Our Ref: PEF/SD/28854
Your Ref: Y/21/18/DOC

30 April 2018

**Drainage
Land at Kings Close, Yapton**

JOB NO.
28854
DRAWING NO.
106
REVISION
P2

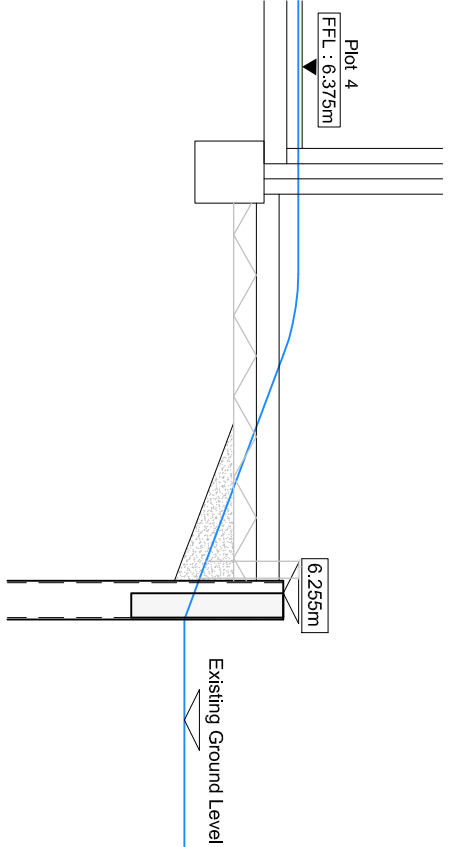
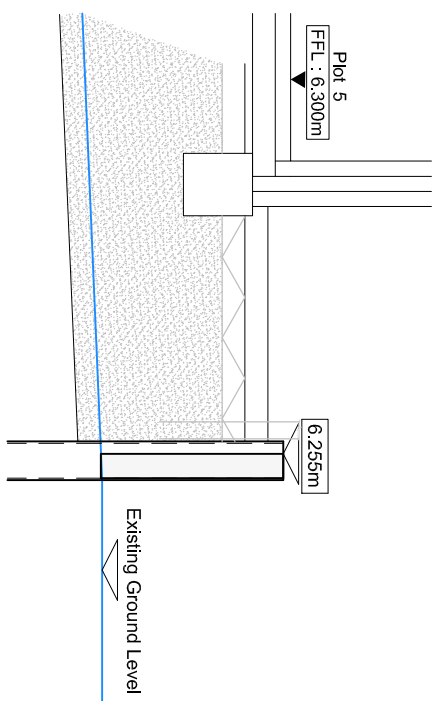
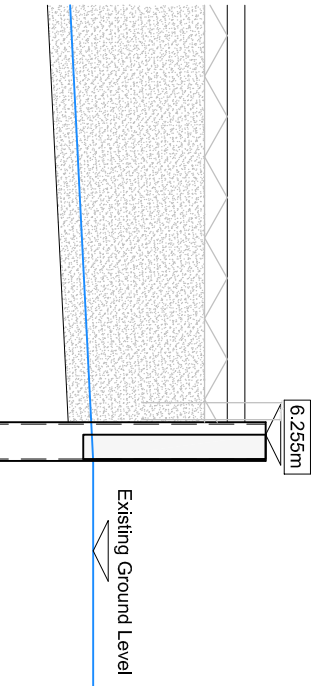
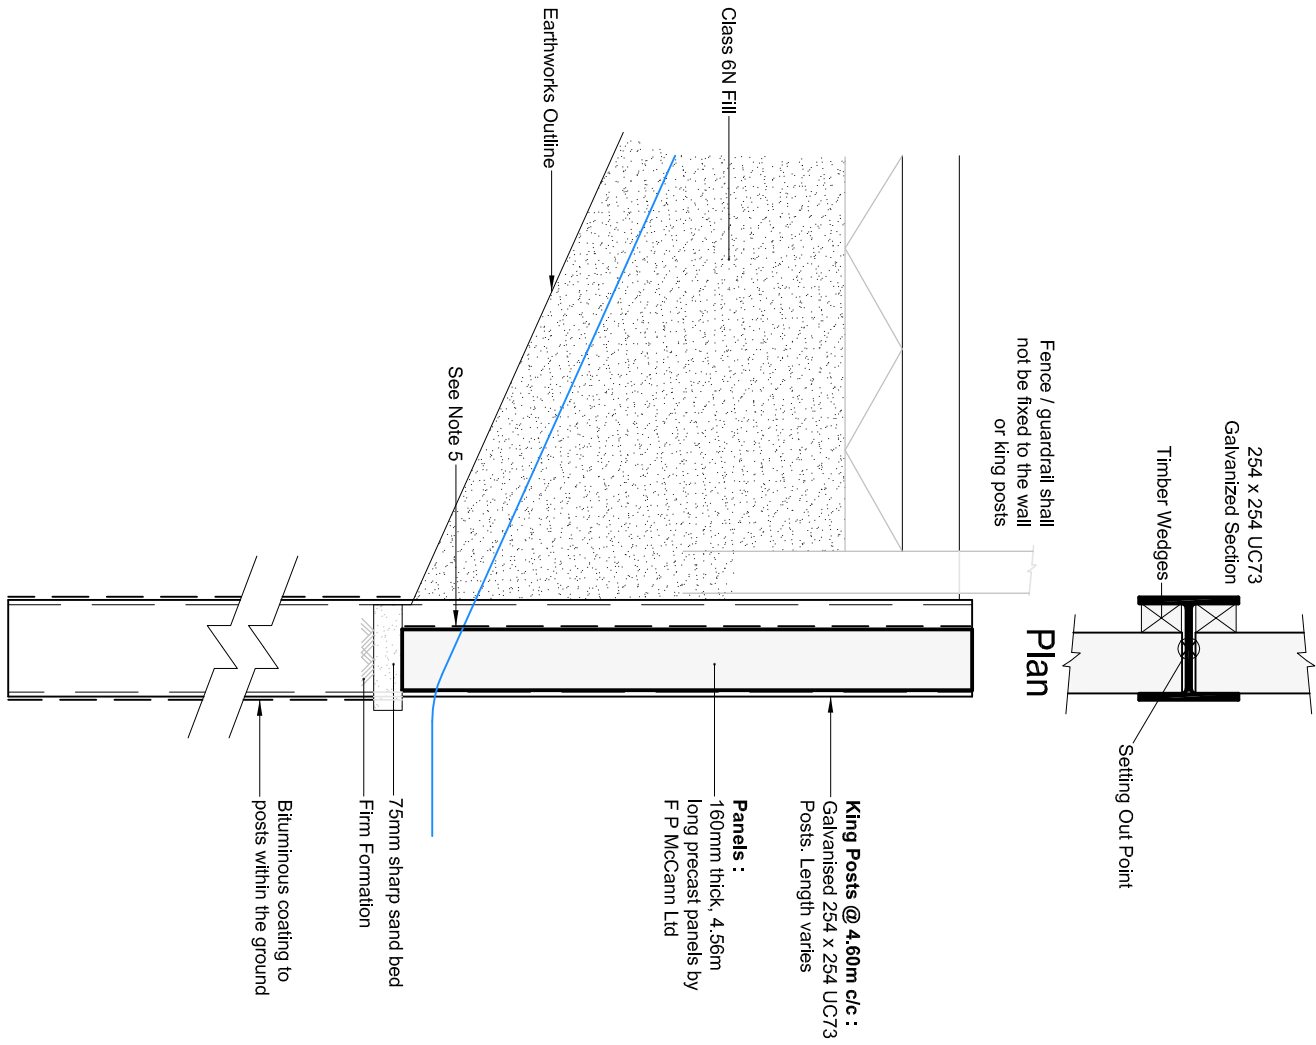
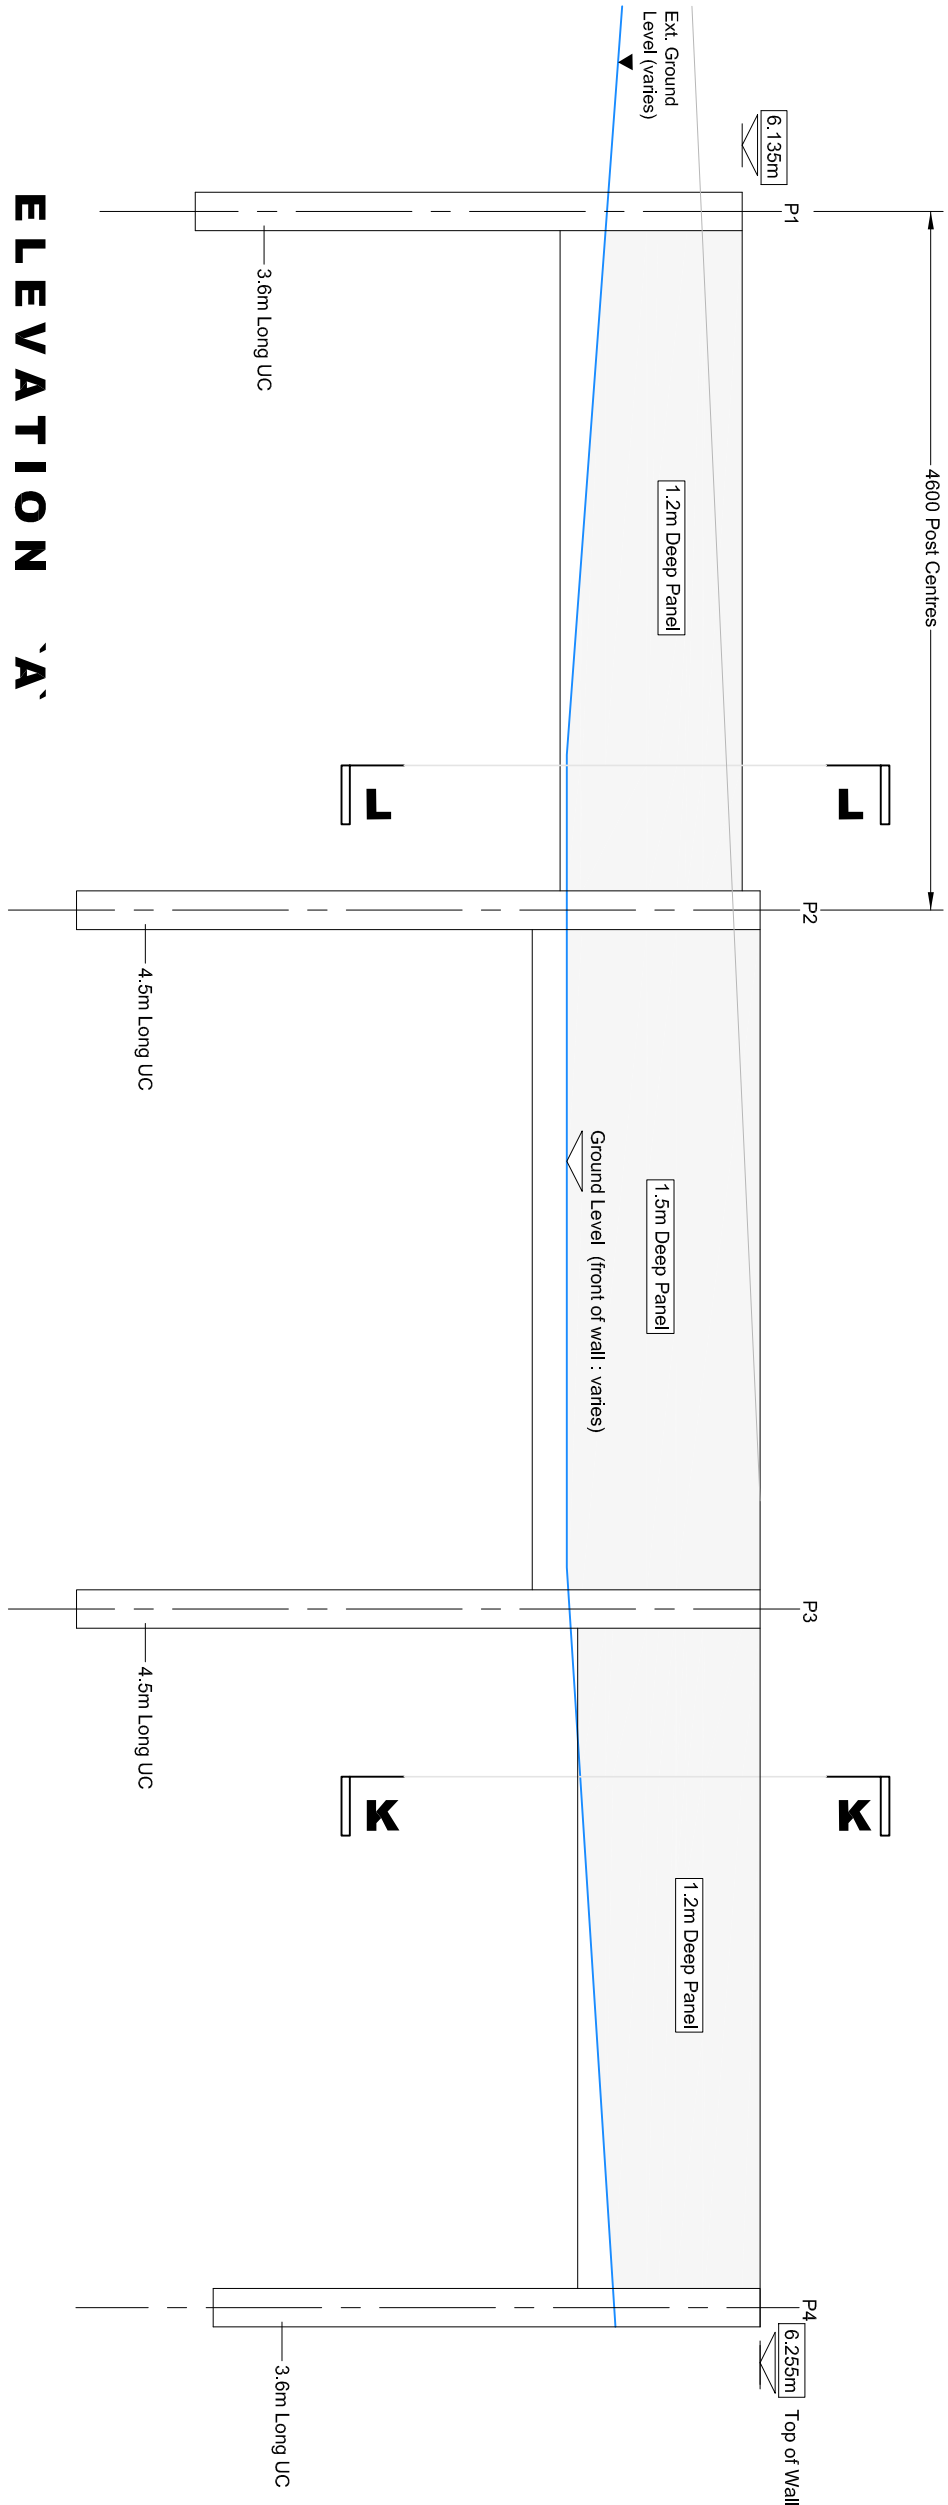
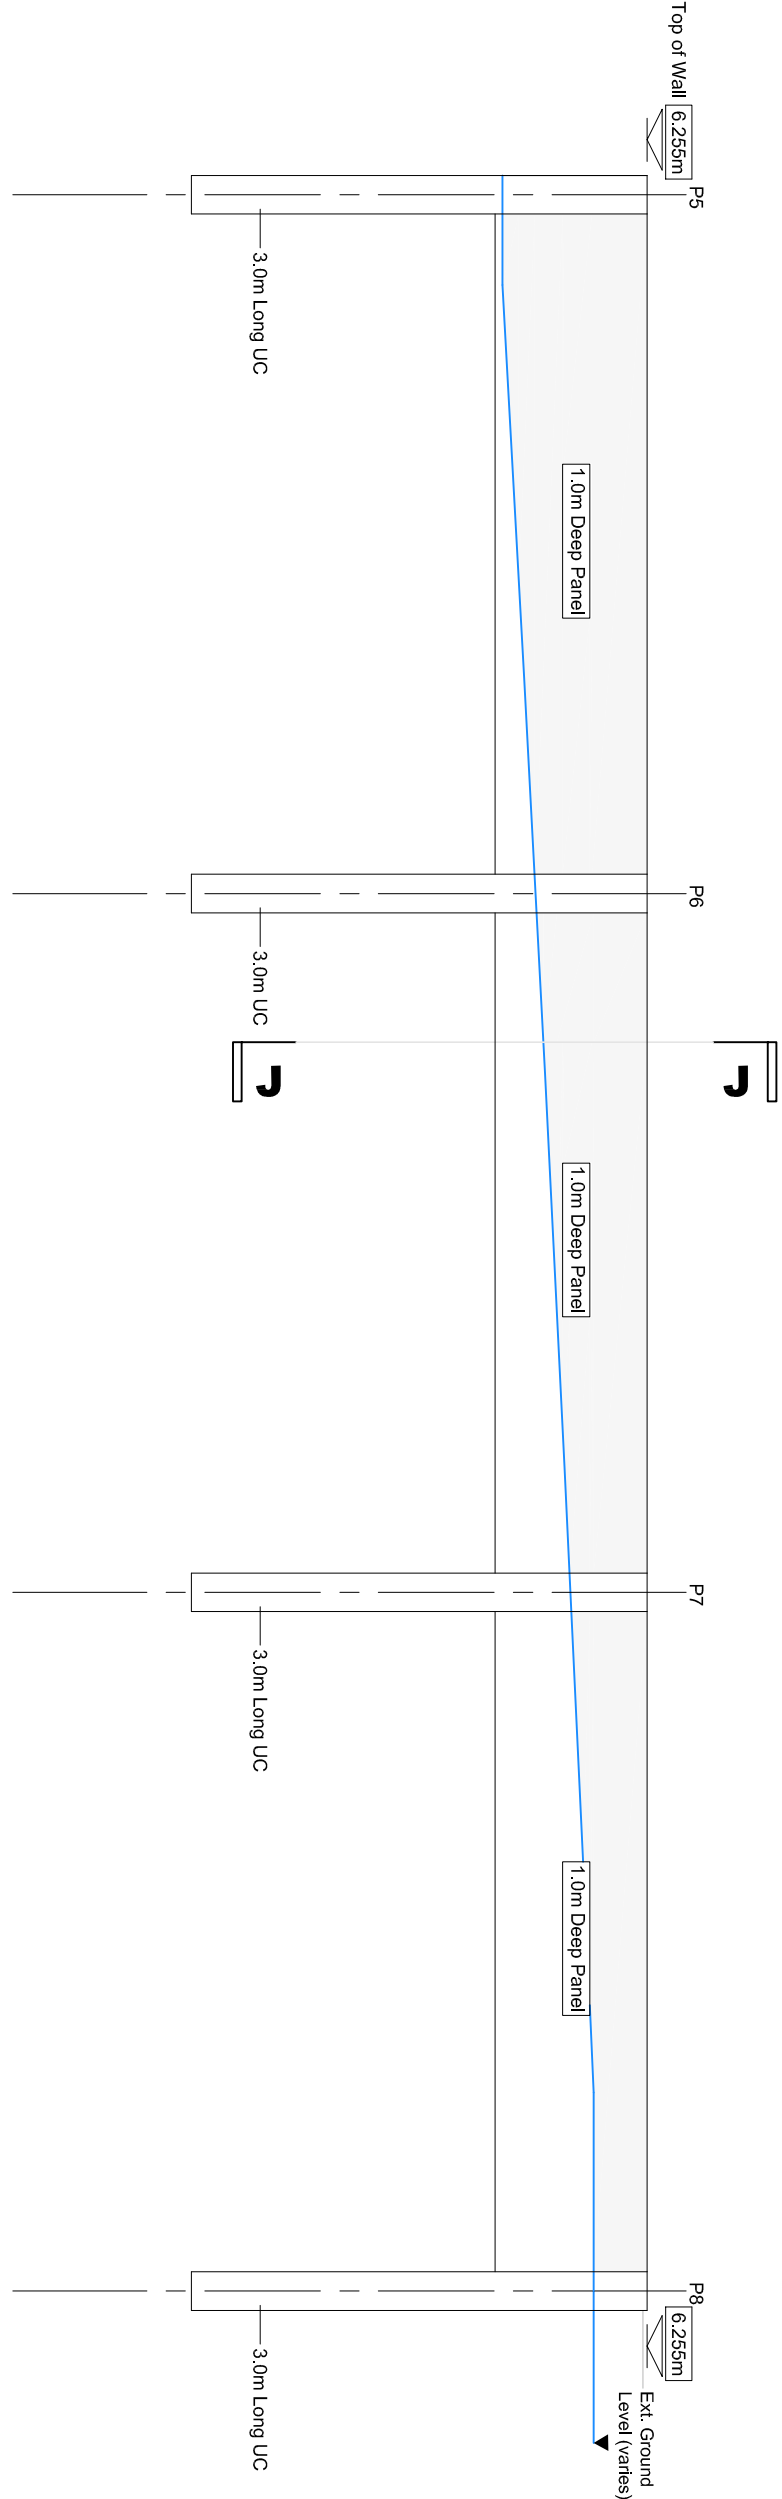
- Soakaway base and cover levels have been added to our drawing No. 28854-101.P4. Base levels represent the invert level of the storage void former.
- Step rungs have been added to our drawing No. STD.01.47A. Manholes Type P2 have not had step rungs detailed to accord with adopted manhole details.
- The depth of the concrete bed at the base of the catchpits has been increased to 225mm.
- Manhole cover types and grades are shown on the schedules and standard drawings. Cover grades A15, B125, C250 and D400 imply compliance with BS EN124.
- Our marked-up drawing shows flood exceedance flow routes.
- Drawings 106.P2 and 107.P1 show sections through the proposed king post retaining wall.
